Re: St Aloysius College, Rozelle | 2A-2B Gordon Street

Reference is made to our engagement to undertake a review of the proposal building works against the Deemed-to-Satisfy Provisions of the Building Code of Australia 2019 (Amendment 1). As part of the proposed building works there will be a fitout undertaken within the classrooms of the subject building.

2A-2B Gordon St - L1

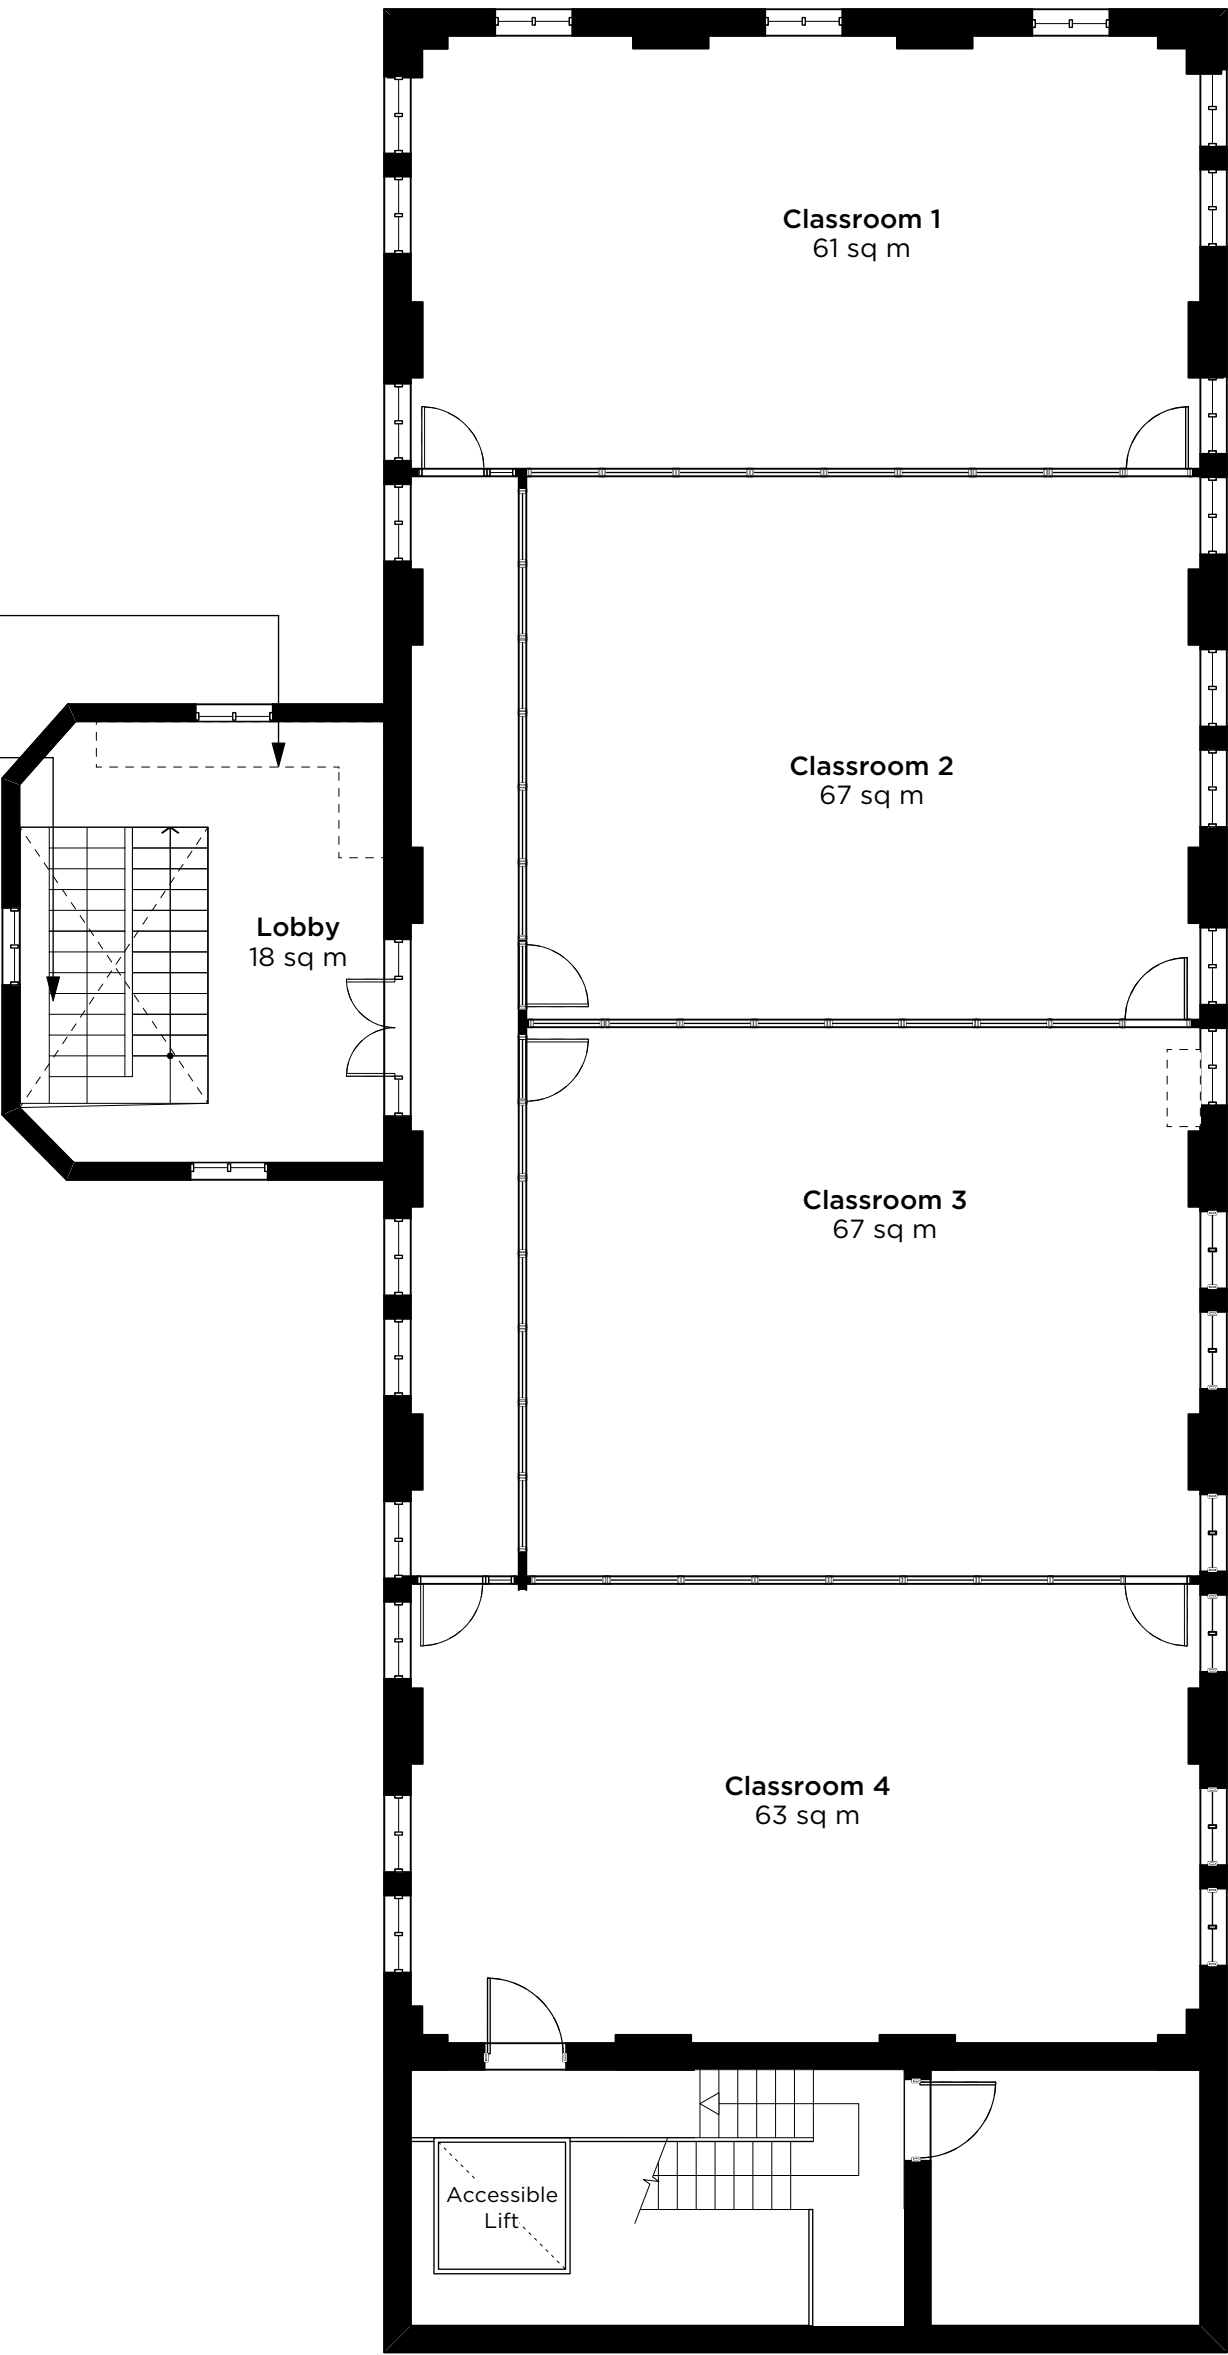
The proposal will contain the fitout of four (4) classrooms within the existing building perimeter with minimal modifications being made to the building structure, these proposed classrooms will be classified as Class 9b Building. The existing storey is provided with access to two stairways which will allow for travel distances and number of exits being maintained in accordance with BCA Part D1.

Although access to the storey is not provided with lift access it would be proposed that a level of access shall be maintained throughout the storey in accordance with the provisions of AS1429.1-2009. To achieve this, it would be required that suitable door circulation and clearance are maintained to each of the classrooms. Provisioning to achieve this would require the doorways to maintain a clear opening of 850mm and latchside clearance in accordance with AS1428.1-2009.

When reviewing the works being carried out it is noted that they will be a minor fitout of the existing structure and would not increase the spread of fire throughout the building or to adjacent buildings. However, as part of the new works being undertaken it is proposed to upgrade the existing emergency lighting and exit signage and an upgrade of existing stair handrails/barriers throughout the egress paths for compliance with the latest revision of the BCA where required.

The existing stairways are considered to be adequate to allow for the population to egress. Each of the existing handrails are capable of being modified as part of the building works to ensure a suitable level of compliance is maintained with the BCA and where required a Performance Solution may be sought during detailed design to accommodate for any existing stairway configurations.
